Please ask for: Jonny Cooper
Email: jonny.cooper@arun.gov.uk
Telephone: 01903 737532
Our Ref: BR/187/24/PL
Your Ref:
Date: 1st October 2024

Application for Planning Permission

Development: Conversion & Change of Use of Single Storey Former Printers Workshop to Form 2-Bed Dwelling with Cycle Parking & Refuse Storage Facilities.
Location: 47 Aldwick Road Bognor Regis PO21 2NJ

Proposed Ground Floor - 1:50

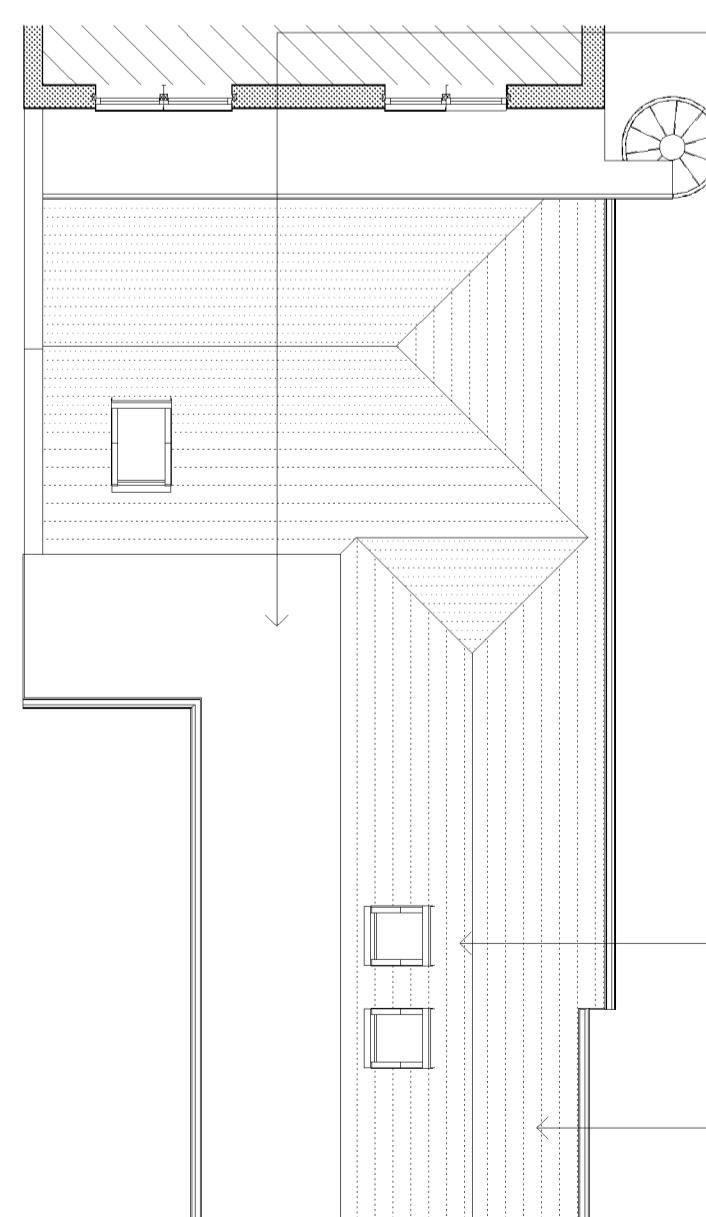
All the scale bars on the plans provided (other than the cycle and bin store plans) scale at half the indicated length. Please amend accordingly and resubmit.

Site Plan 1:500

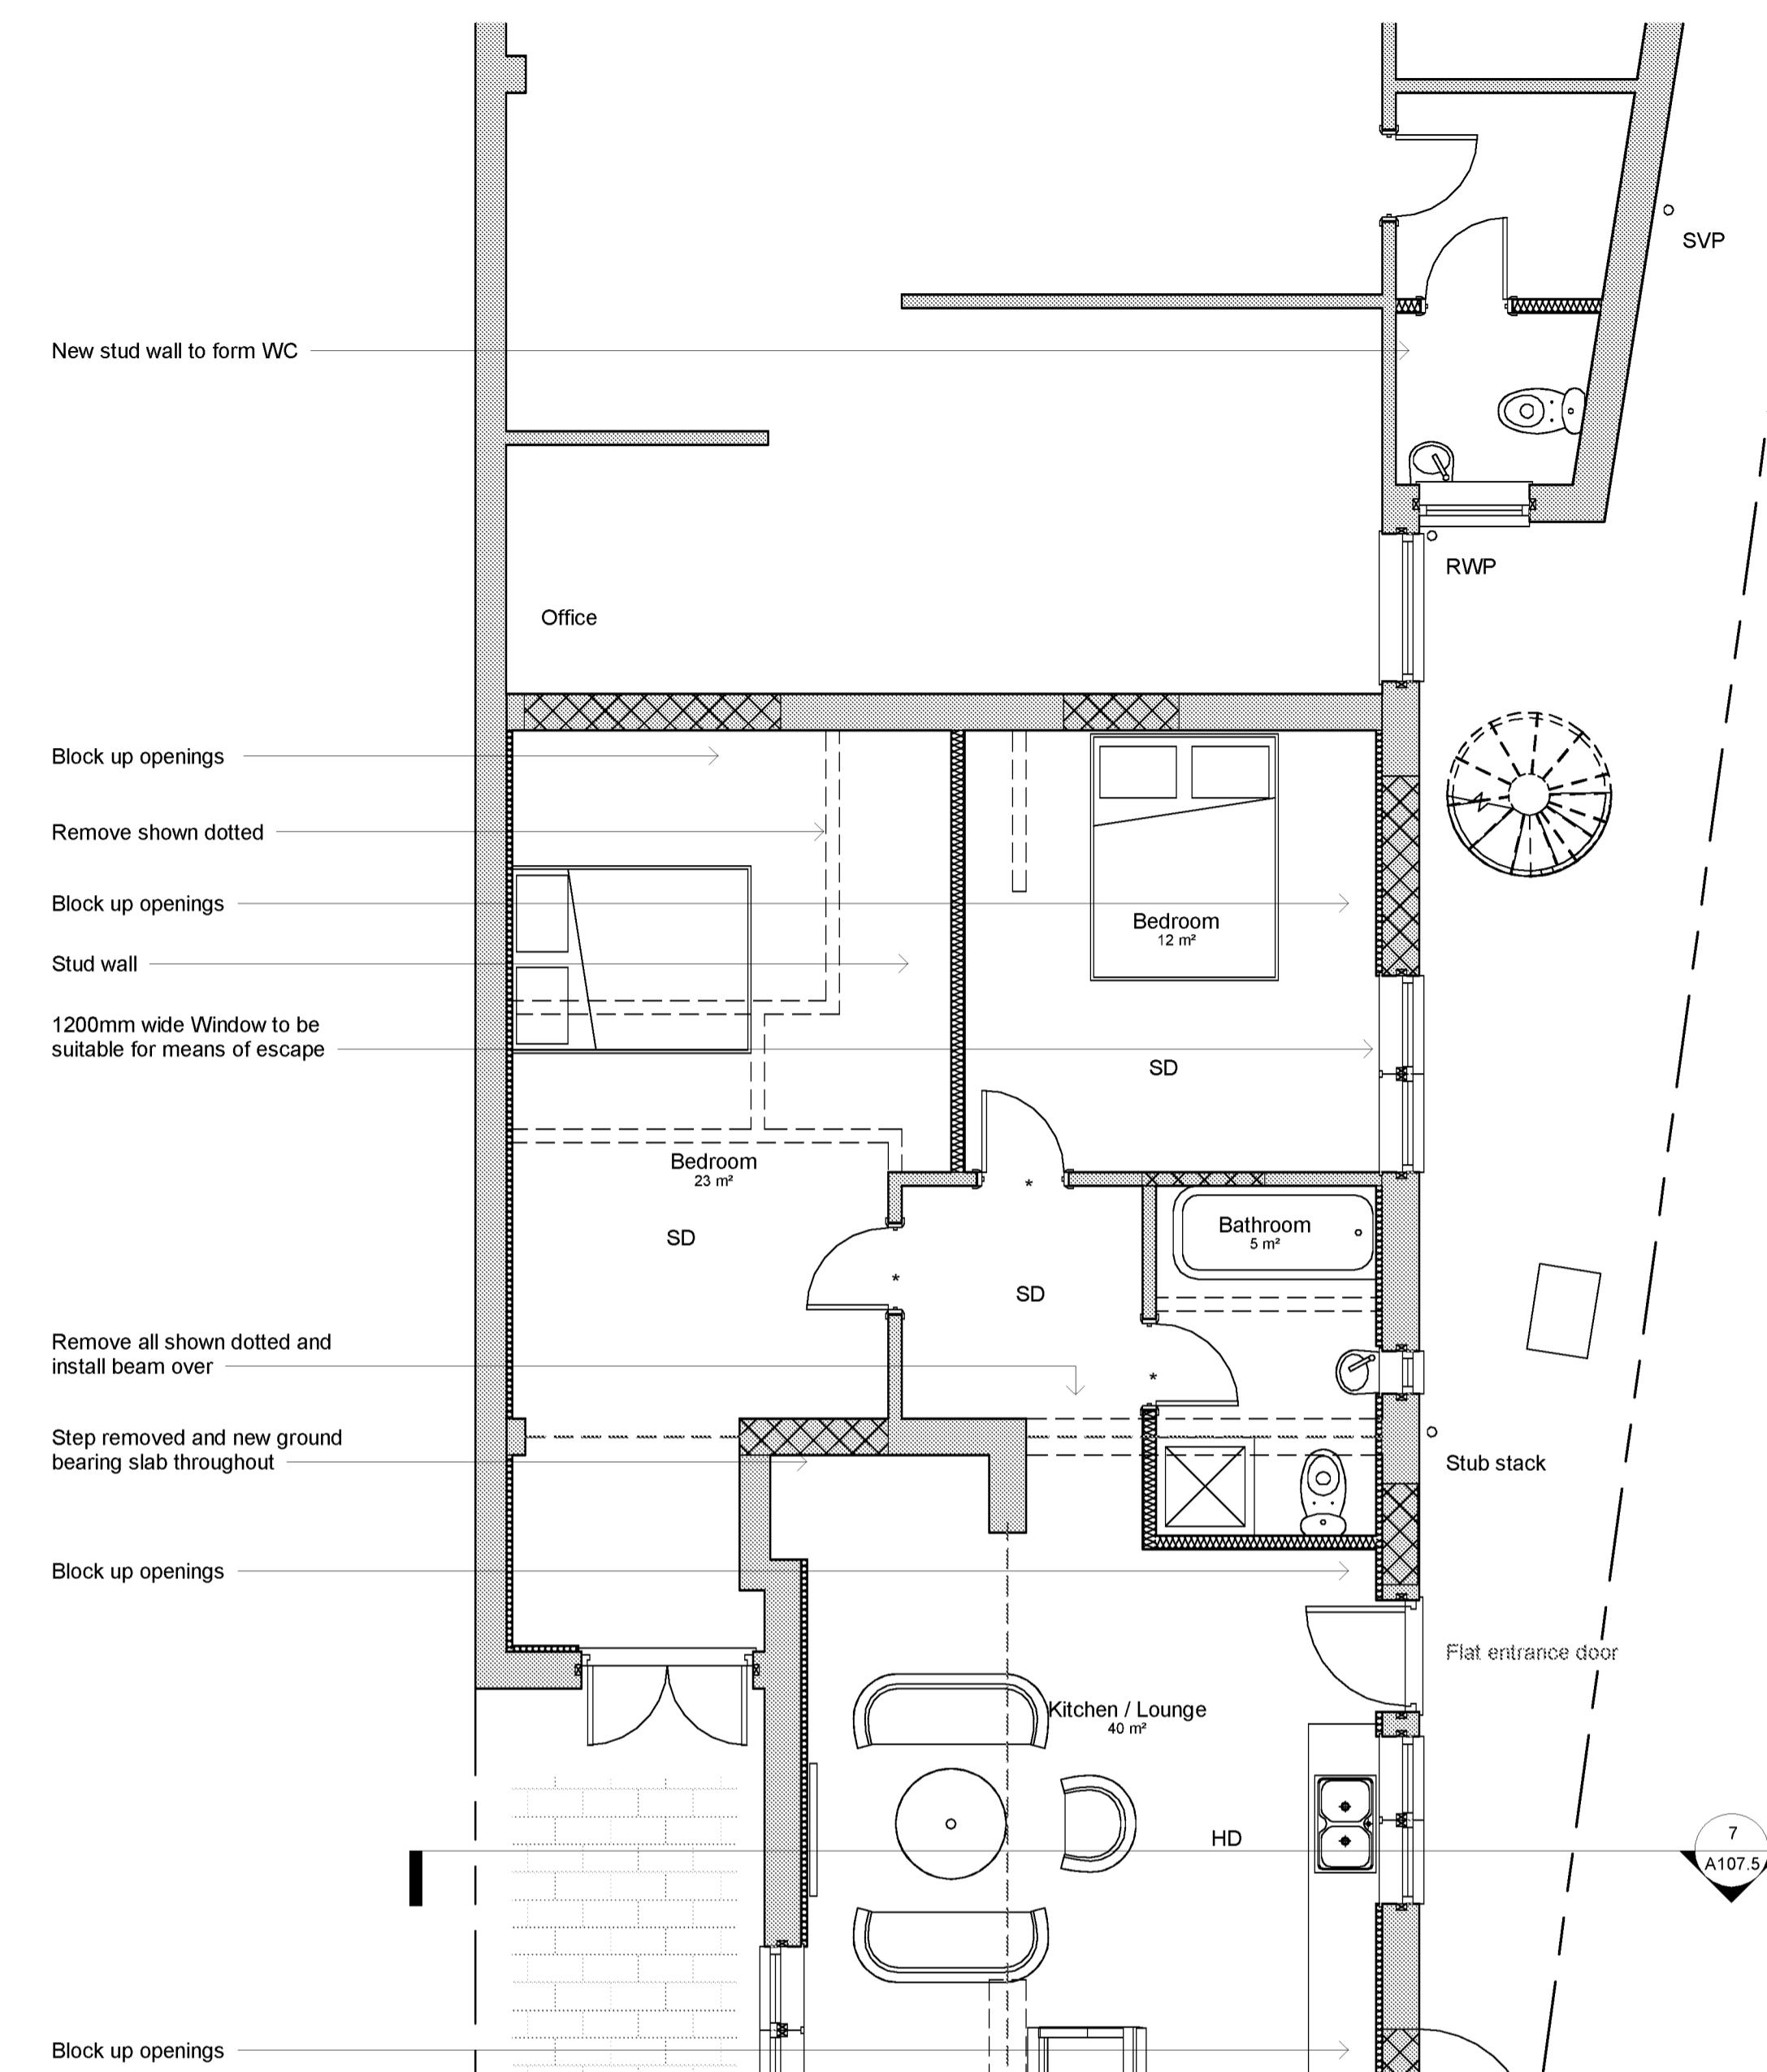
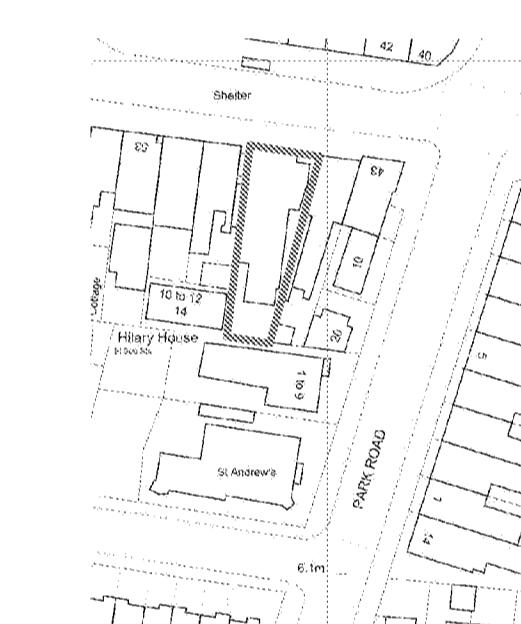
Block Plan

Please submit an electronic block plan in pdf format at a scale of 1:500. Further details of what must be included on the plan can be found in the Validation Requirements List.
